**WEST SUSSEX COUNTY COUNCIL
STRATEGIC PLANNING CONSULTATION**

SUBJECT: FP/159/13

Change of use from production of timber for bio mass use (Sui Generis) to land for private outdoor fitness training (D2 Assembly and Leisure) (resubmission of FP/102/13/). This application is a Departure from the Development Plan.

Land at Rookery Farm, Worms Lane, Flansham, West Sussex

Site Plan

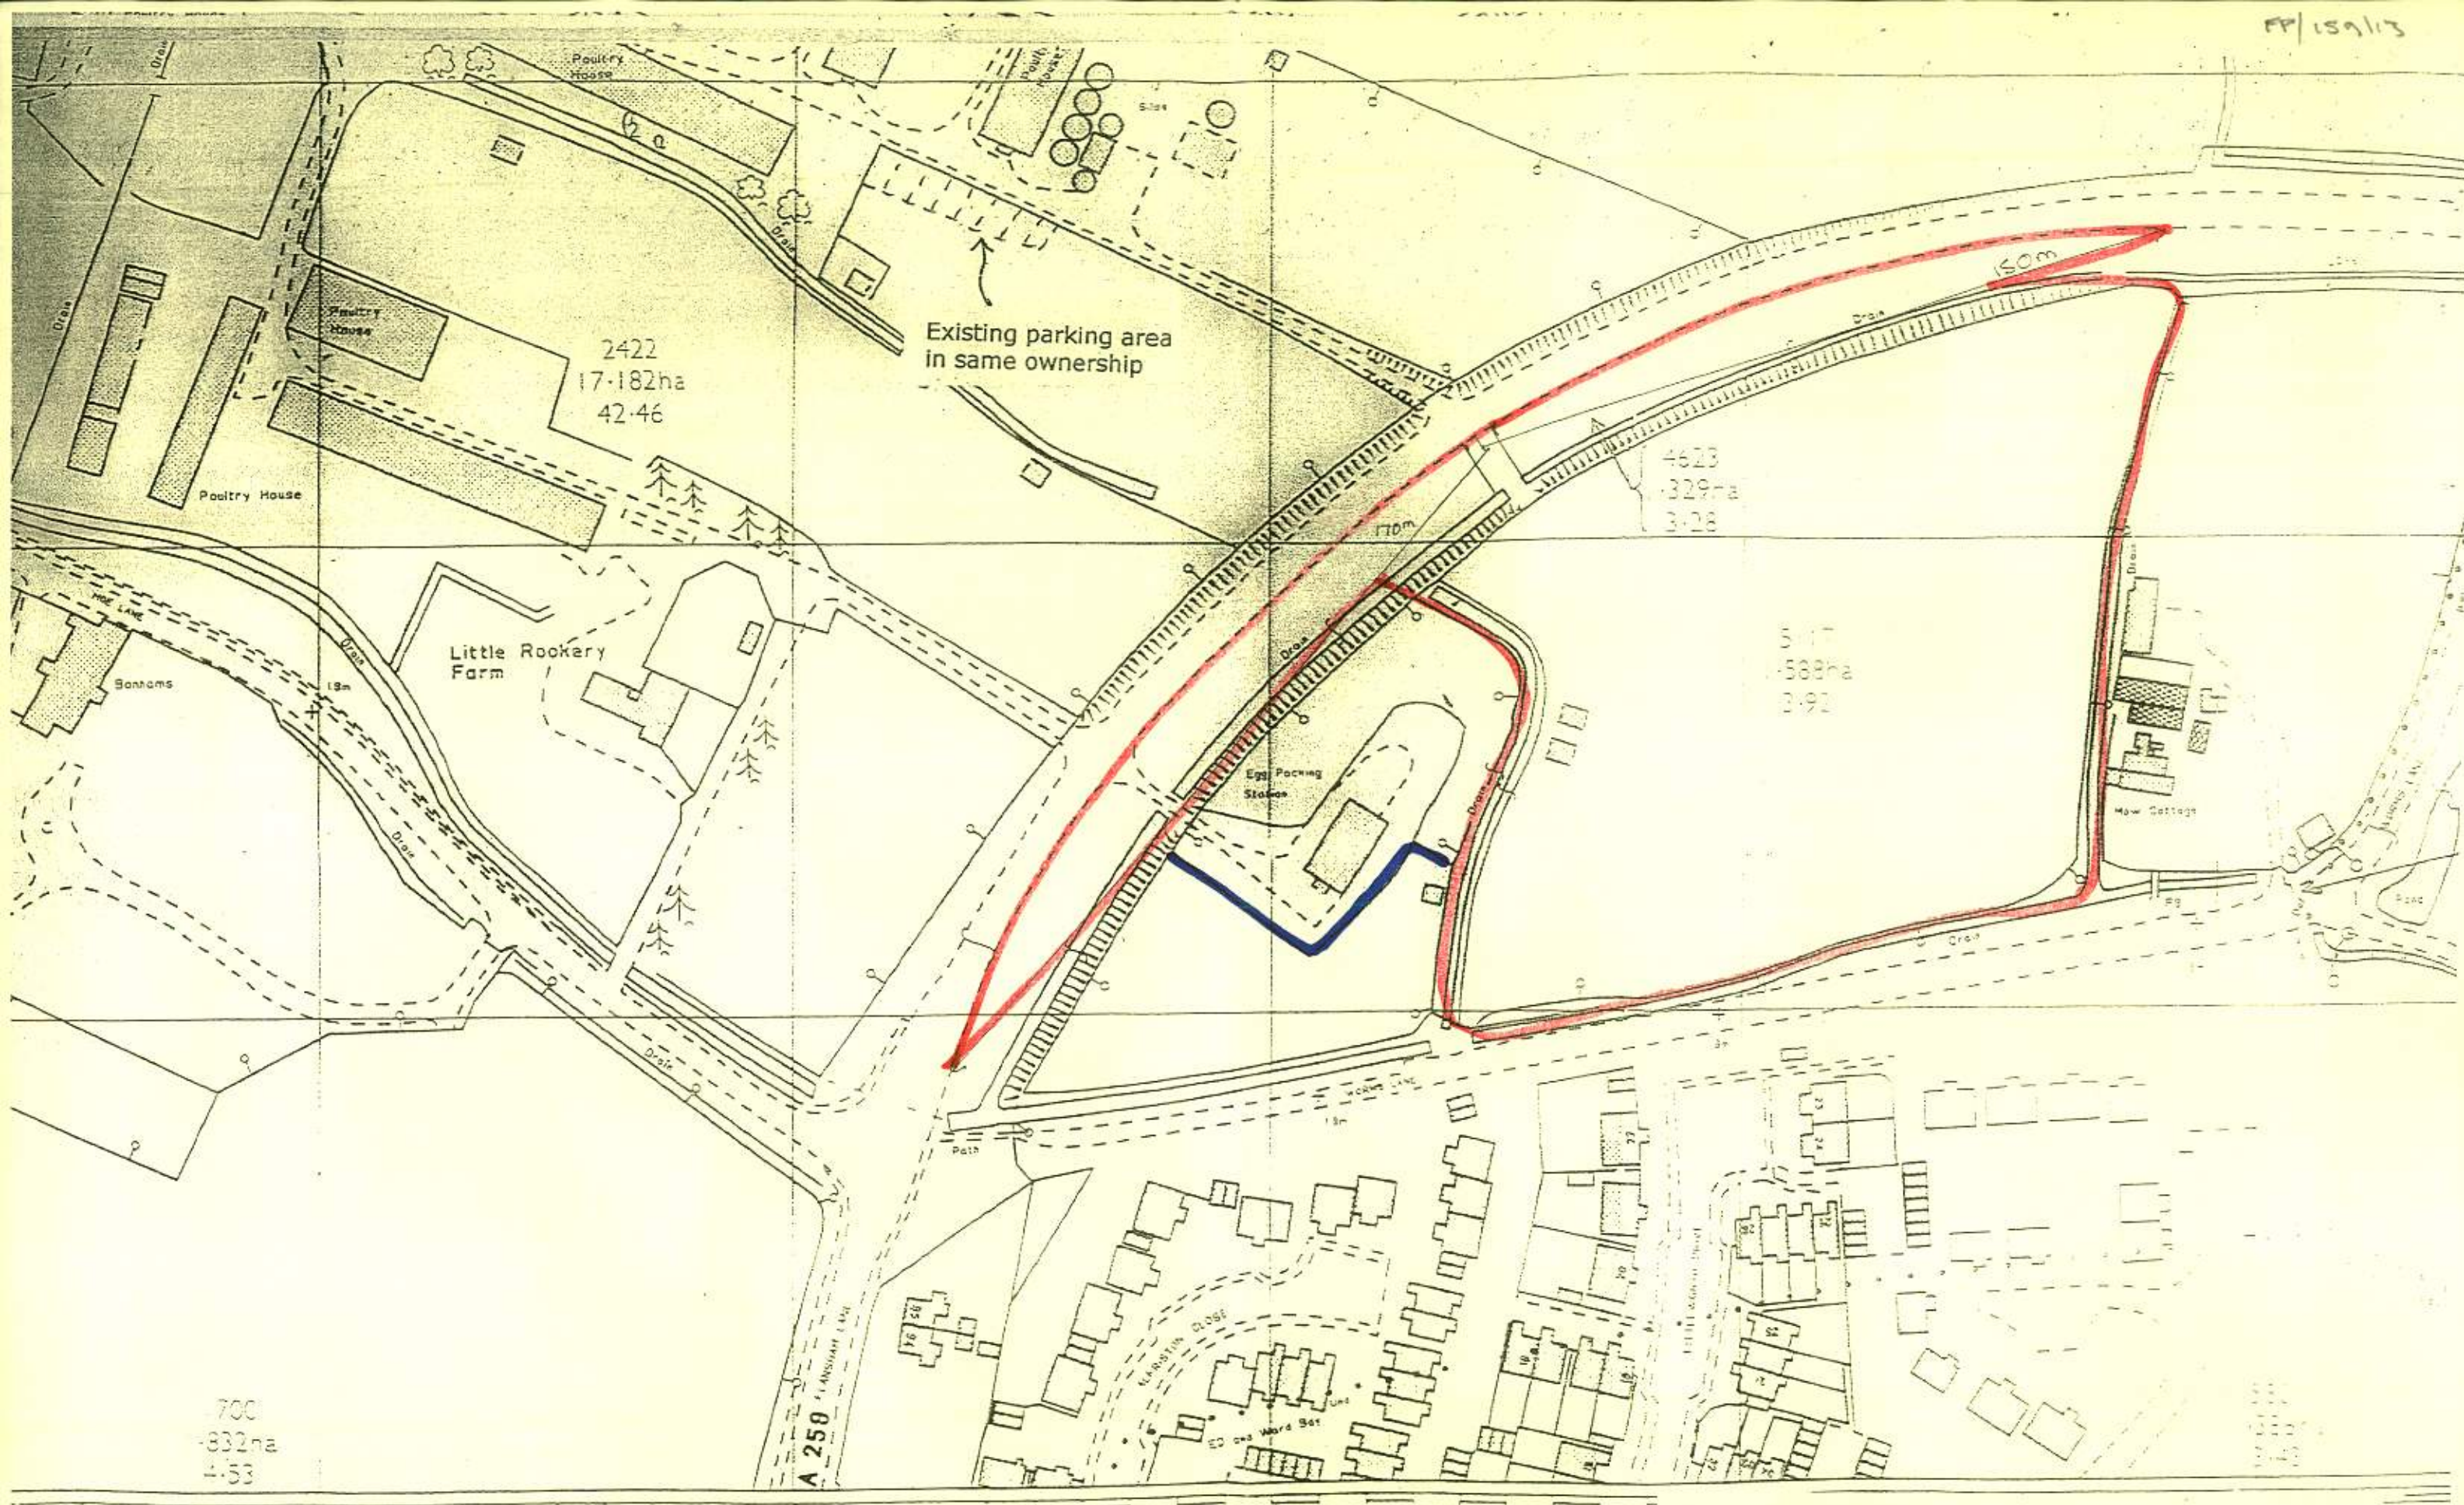
The Applicant has stated that there will be no direct vehicular access to the site and that visitors will be expected to cycle or walk. Given the nature of the use it would be anticipated that the site would have a relatively large catchment area and that it is unlikely that all users of the site would be located within a reasonable walking or cycling distance from the site, or would be inclined to walk or cycle regardless of distance. Some users, such as groups of children or disabled users, are more likely to seek access by vehicle. Car parking will be made available at the existing Rookery Farm shop (although it should be noted that while this is under the control of the Applicant it is not included within the site boundary and the provision could be lost should this land change ownership) to the north of the A259 for those wishing to drive to the site. Pedestrians would be required to cross the A259 in order to access the site which is located to the south of the A259. Speeds along this section of the road are derestricted and daily traffic flows are high; while we do not have a counter at this specific location, an auto-counter further along the A259 shows the volume of traffic to be in the region of 15,000 daily movements and peaking at 1350 movements per hour, the equivalent of 1 movement every 2.5 seconds. Crossing opportunity would be limited and could result in pedestrians growing impatient and crossing at unsuitable times, running the risk of being struck by a vehicle travelling at speed.

Further to this, there are no pedestrian facilities along this section of the A259. Pedestrians would be directed to and from the bellmouth junction of Rookery Farm and onto a grass verge on the opposing side. Conditions would be worsened after periods of inclement weather where the grass verge may be wet or muddy and could result in pedestrians slipping onto the carriageway or encouraged to walk alongside until a suitable section of verge can be found. Such a provision would also be inappropriate for use by disabled users although use of the site is being promoted as such.

Pedestrians emerging from Rookery Farm to cross the road could obstruct the path of vehicles leaving the A259 to enter the Rookery Farm site and lead to rear shunt collisions between vehicles on the running carriageway who would not be expecting an obstruction to their journey.
